Infrastructure NSW

Sydney Football Stadium Stage 2 (Design, construction and operation) (SSD-9835)  
**Response to Submissions**

# ATTACHMENT 1

Figure 13: Stadium Emergency Exit Plan

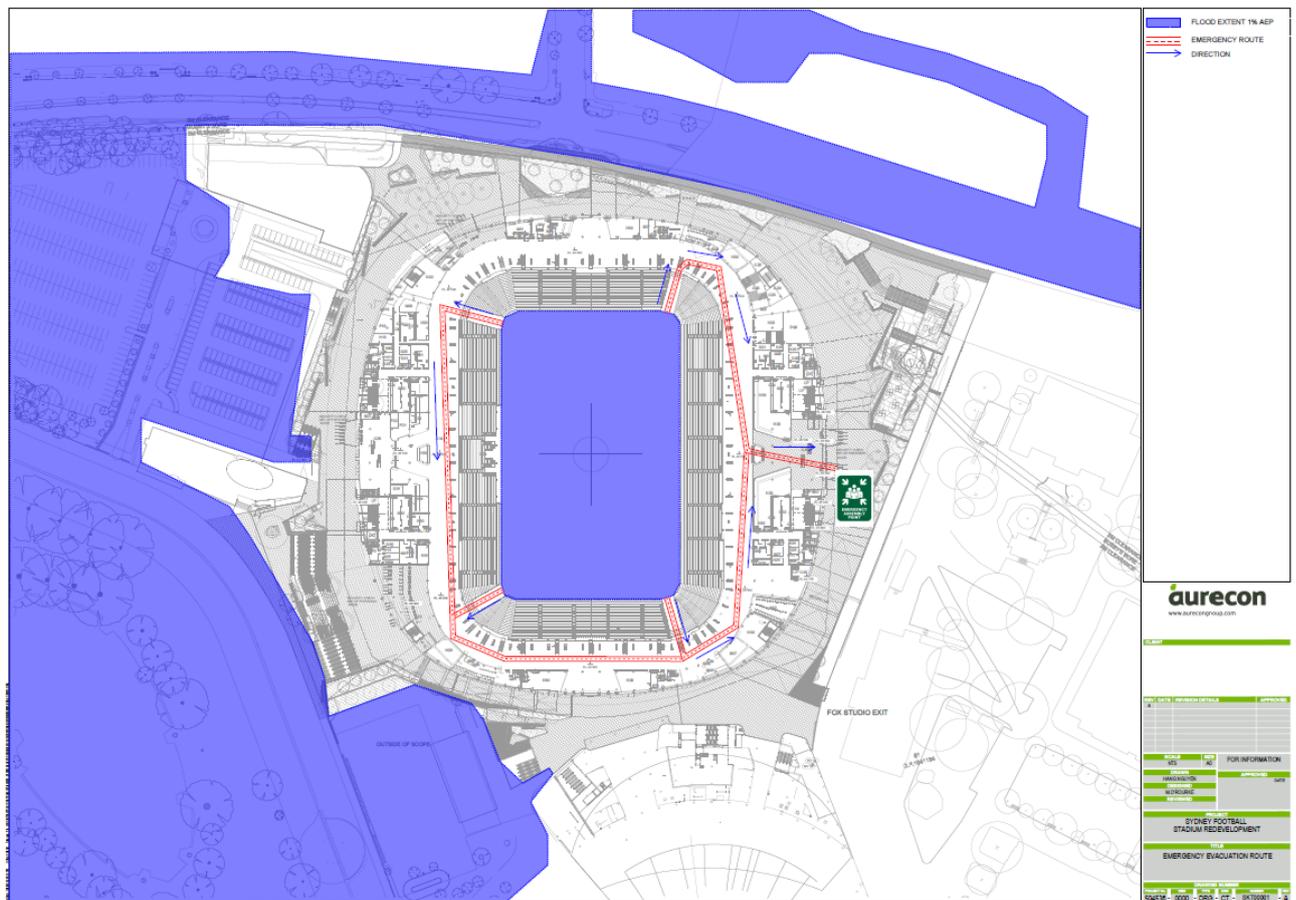
- The Stage 2 application does not include measures to demonstrate that patrons can safely evacuate the site in the event of a large flood.
- Given that the proposed stormwater management plans do not propose any improvements to the existing flooding situation surrounding the site, the above evacuation measures should be provided.

55 Public Domain Circulation Strategy

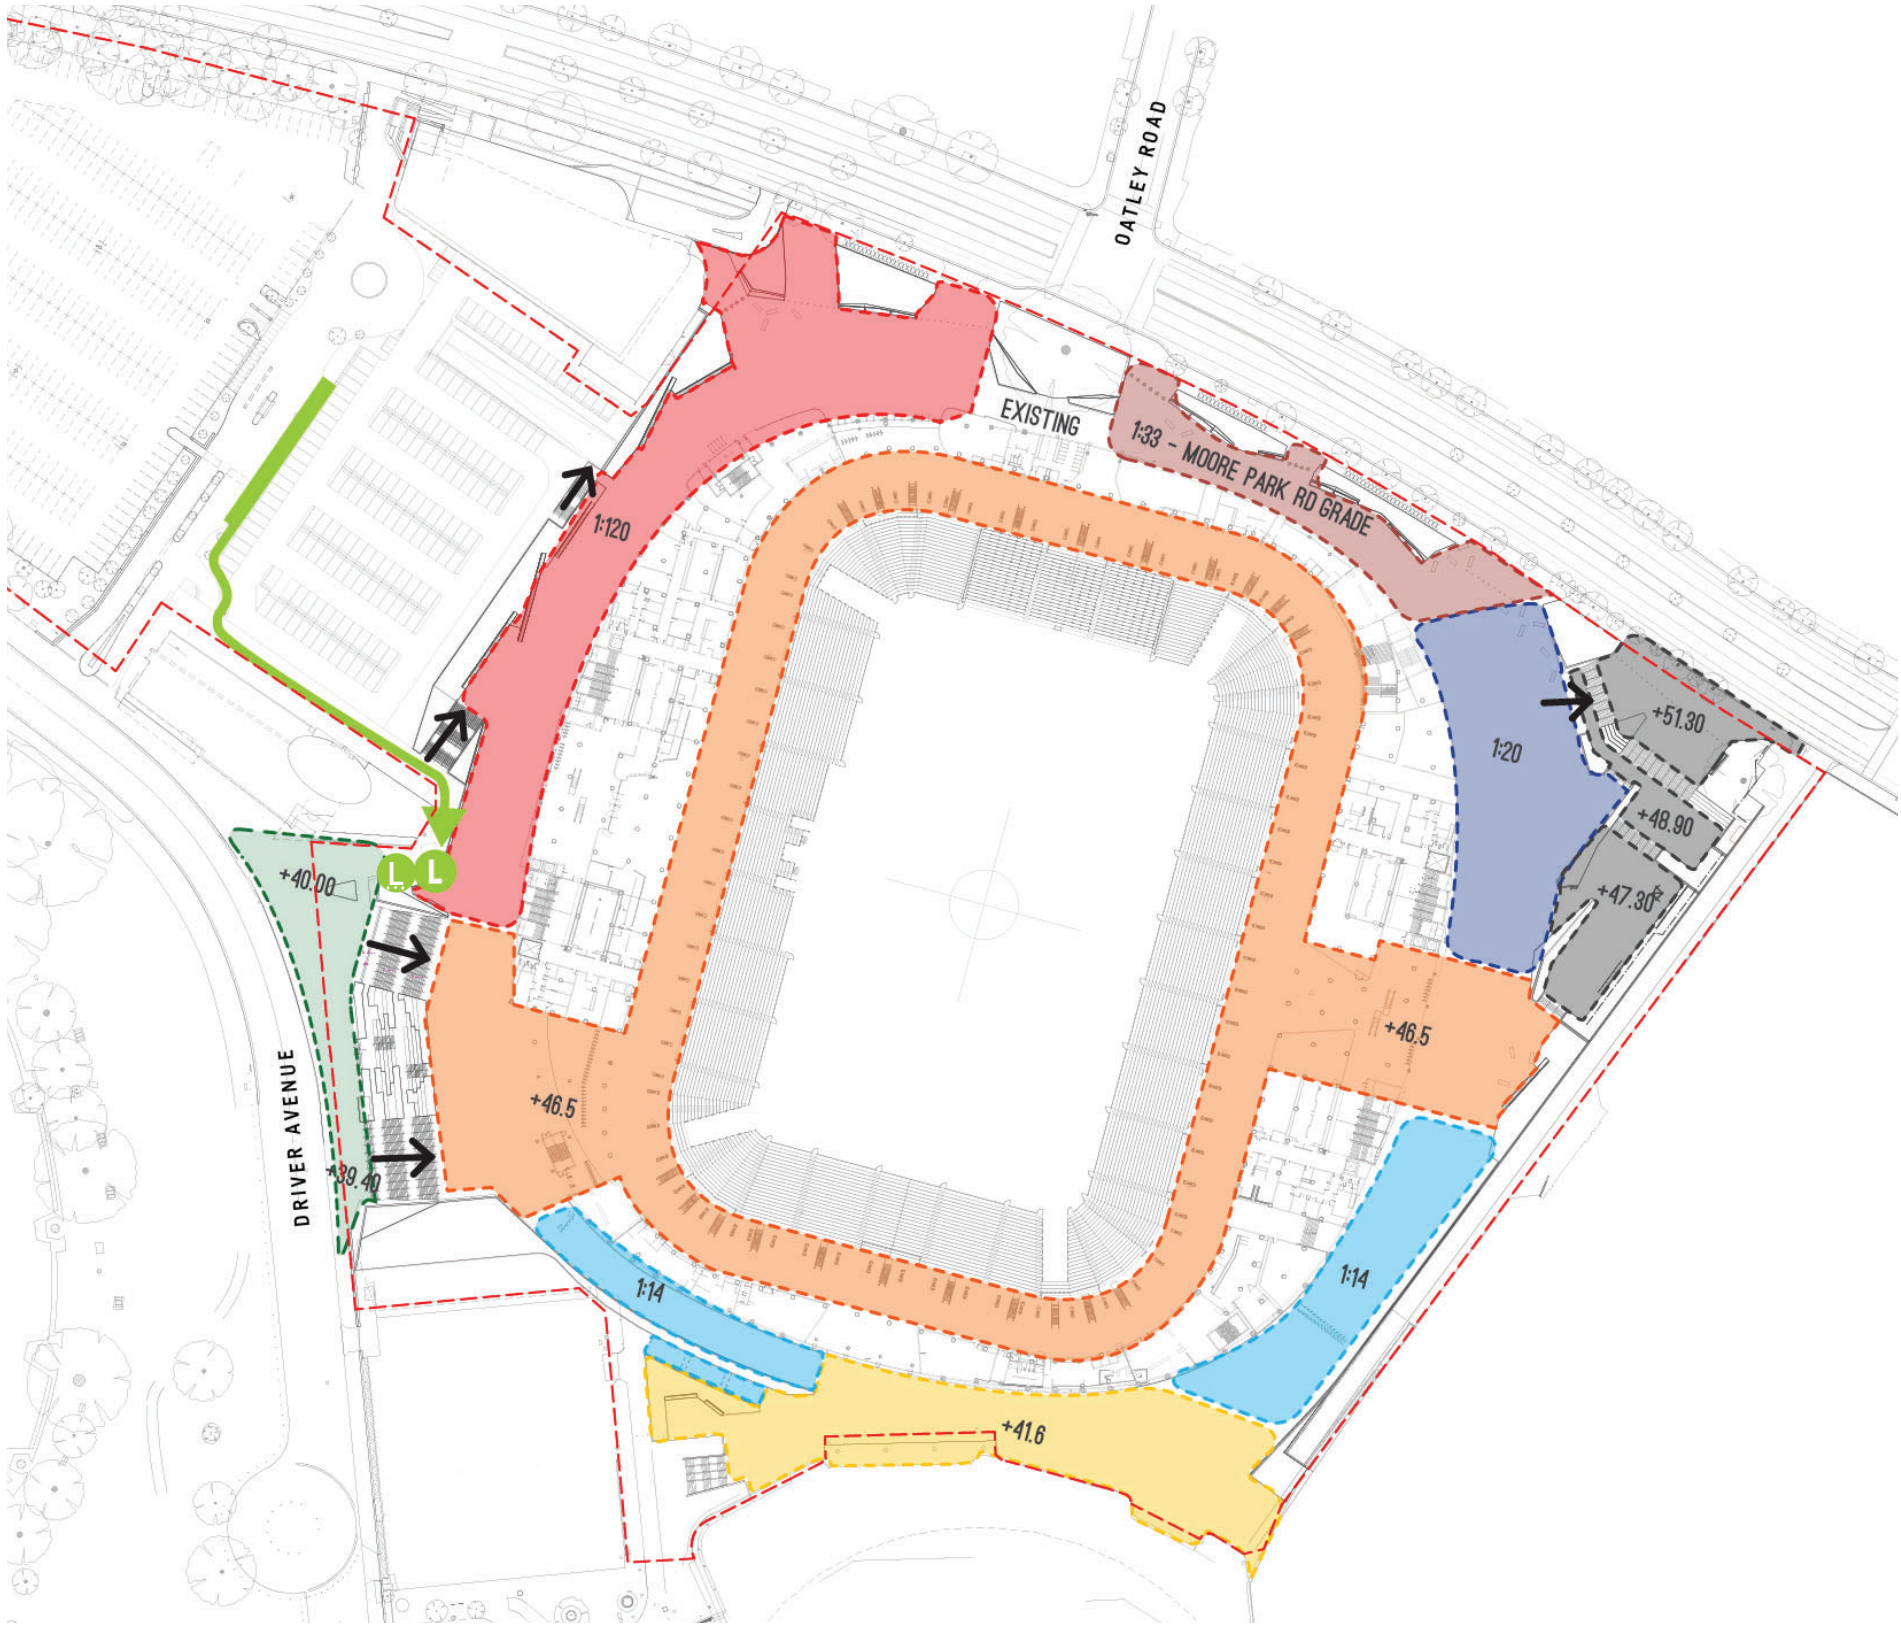
- The Department notes that the drop-off / pick-up areas for patrons with limited accessibility have been proposed within the Moore Park 1 car park (MP 1 car park). However, no direct link is proposed between this area and the at-grade access that is proposed from Moore Park Road.

- The submitted linkage plans show that access from MP1 car park is proposed to the lifts at Driver Avenue. This may not be adequate on an event day, when large numbers of patrons would be dropped off at the MP1 car park.

- Given the above, alternate access to the Moore Park Road entry from the drop-off / pick-up area should be provided.
- Section 6.2.1 of the Event Management Strategy notes that under certain circumstances a “Temporary partial or full closure of Moore Park Road” may be required. This scenario has not been assessed in the Transport Assessment.
